From: Anita Gardner
Sent: 24 May 2017 08:20
To: Planning.Responses
Subject: FW: Re Planning application Re: F/20/16/PL - Conversion of outhouse (B1 Business / B8 Storage & distribution) to form Cafe,

Please can this e-mail be scanned against F/12/17/NMA as a consultee response

Subject: Re Planning application Re: F/20/16/PL - Conversion of outhouse (B1 Business / B8 Storage & distribution) to form Cafe,

Drawing: PLANS, ELEVATION EAST & WEST PROPOSED			
Drawn JD	Date NOVEMBER 2016	Scale 1:100 @ A3 1:50 @ A1	
Job No. J.1989	Drg. No. C.05	Rev. E	
Drawing status CONSENT

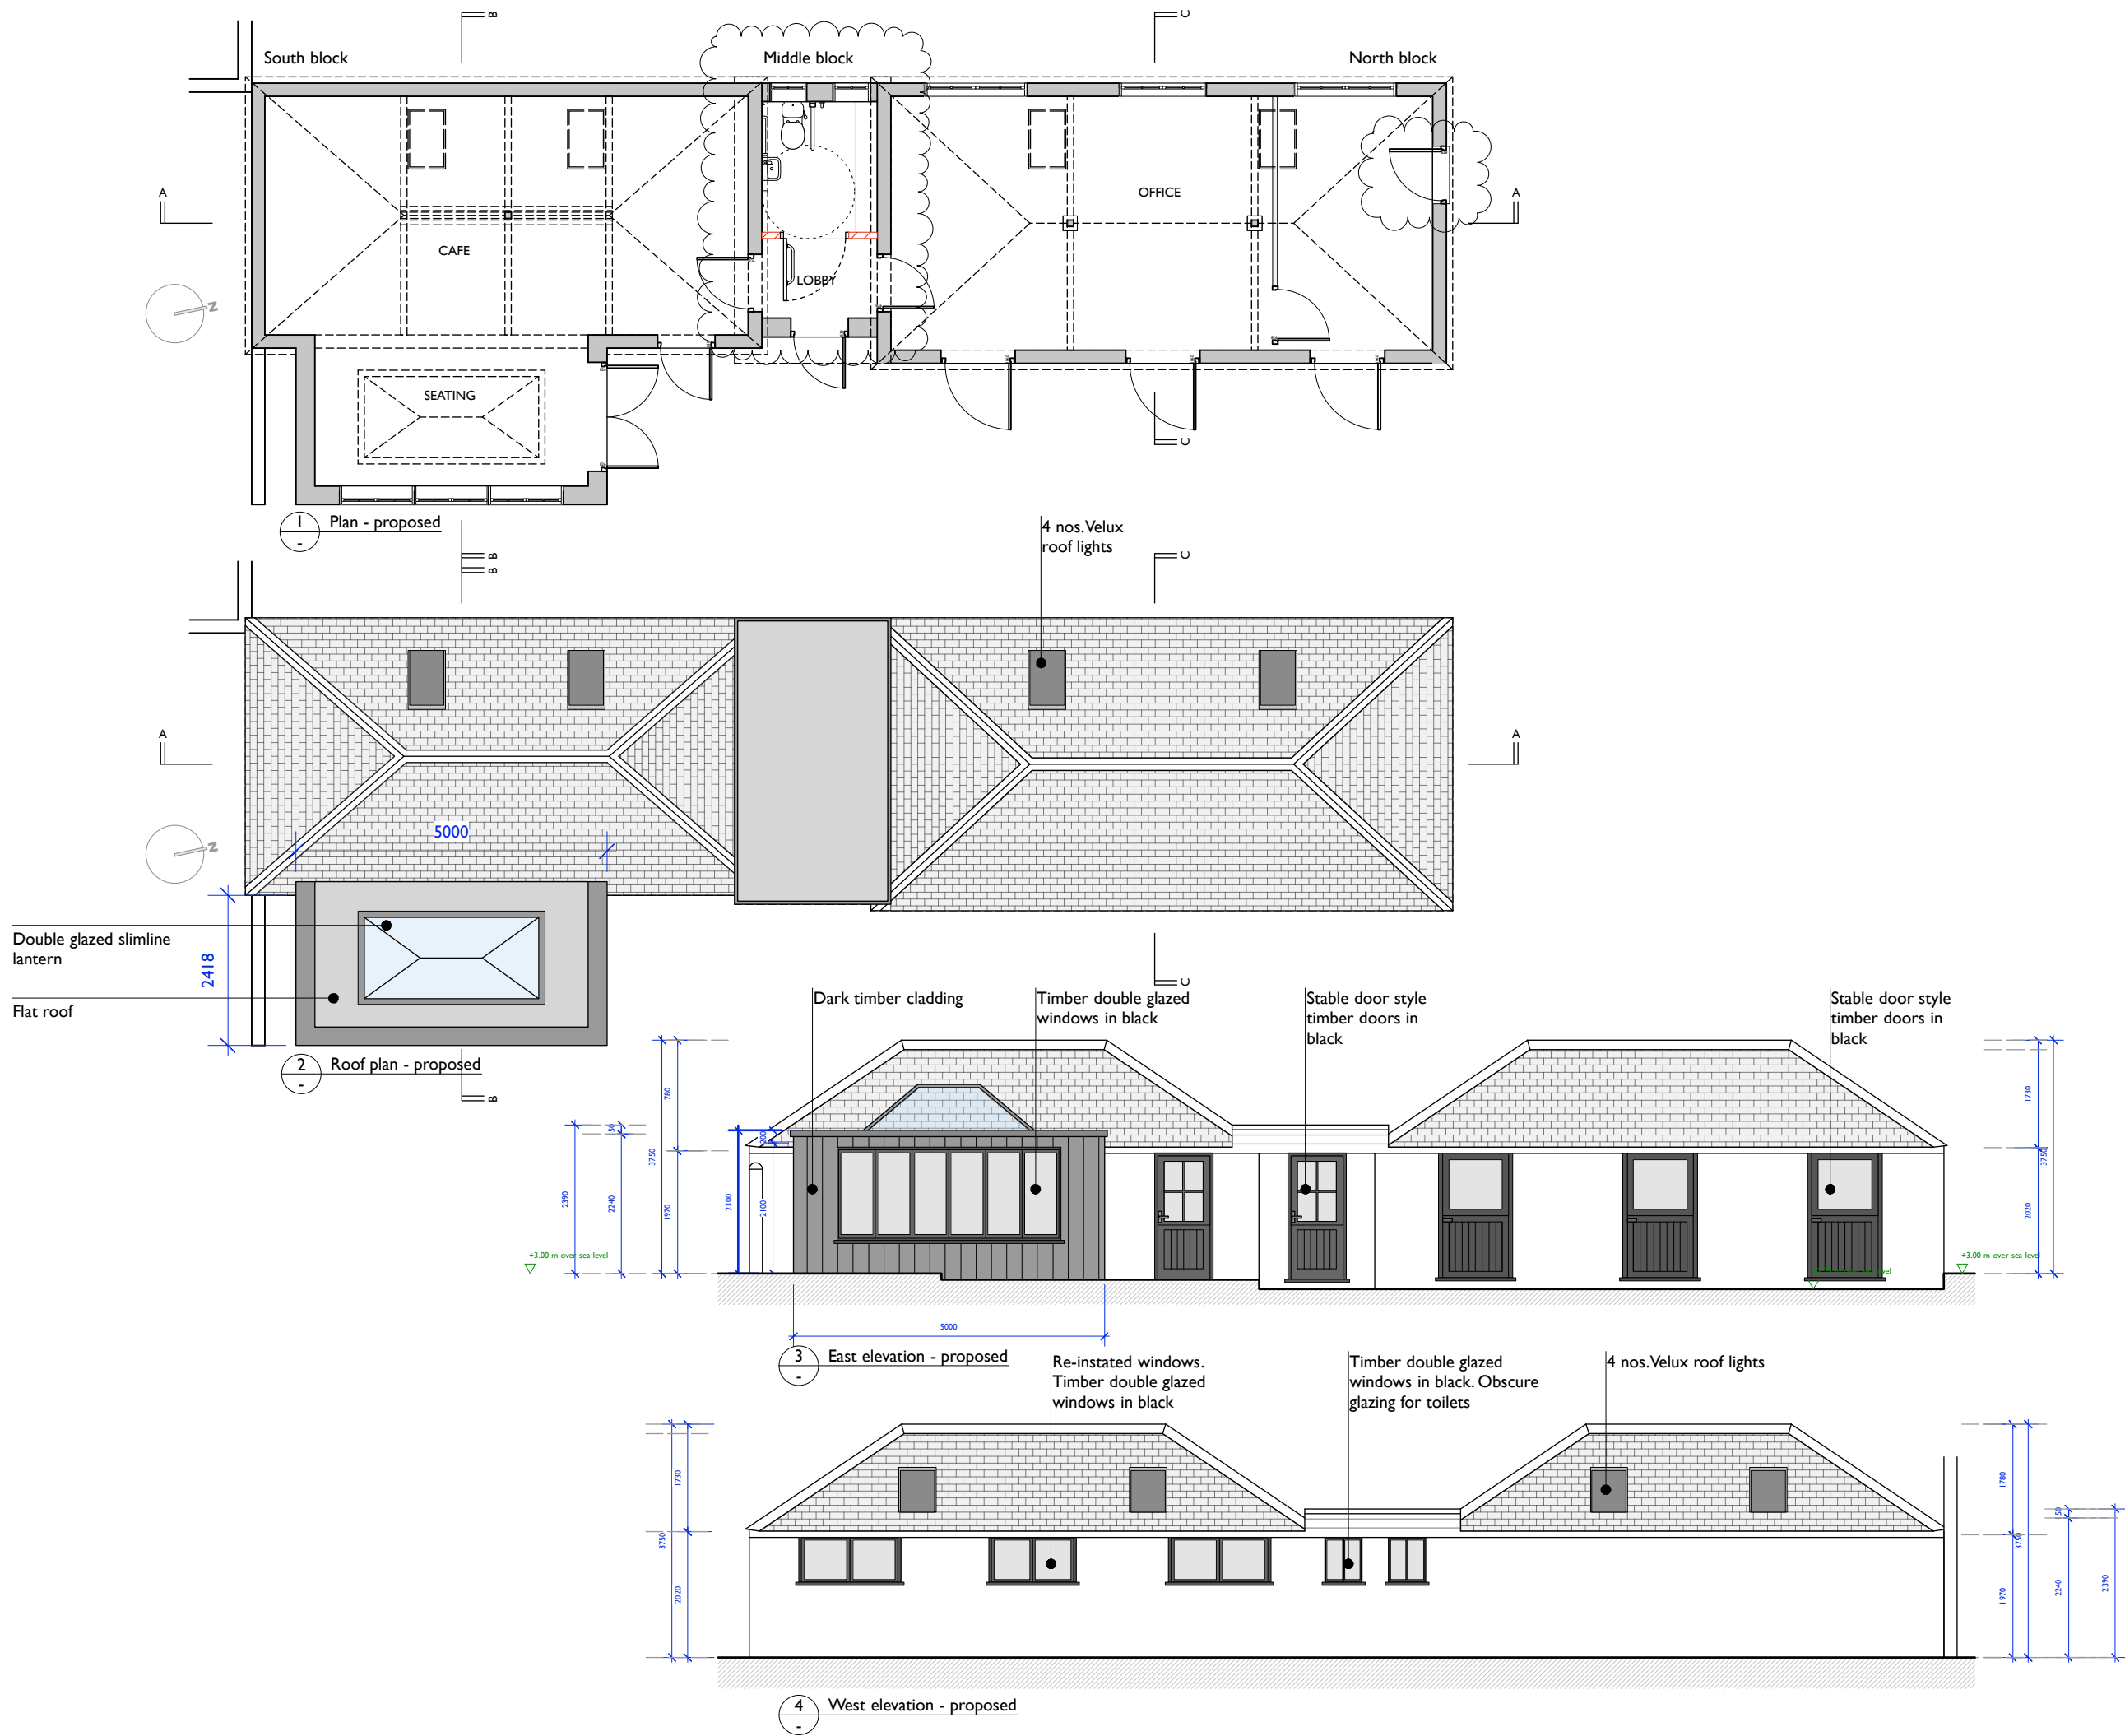
Yes, if you only have 20 covers then 1 toilet would be sufficient.

Please find attached a copy of Arun's Sanitary Provisions. I would still consider from the information that you have provided that you would need to provide two toilets for customer use, one would not be sufficient under Arun's standards.

I will forward your e-mail to the environmental health officer Fiona Fitzgerald and ask her to respond direct regarding point 2 toilet provision. The planning permission is subject to the approved plans which include the layout and provision of 2 toilets. Should you wish to amend this to one toilet you would need to submit an application for a Non Material Amendment for consideration.

2. We have decided that we would like to offer a single toilet which is suitable for disabled use, rather than two as proposed initially. There are a couple of reasons for this – space is limited and the cost of two would be higher to build and maintain.

Furthermore, I have checked with several high street café locations, many of which have up to 50 covers, and they often offer the single unisex toilet facilities (i.e. Starbucks in Chichester). Nevertheless we do already have a further toilet available in the main warehouse should you consider that 2 are indeed required. I would appreciate your thoughts on this.
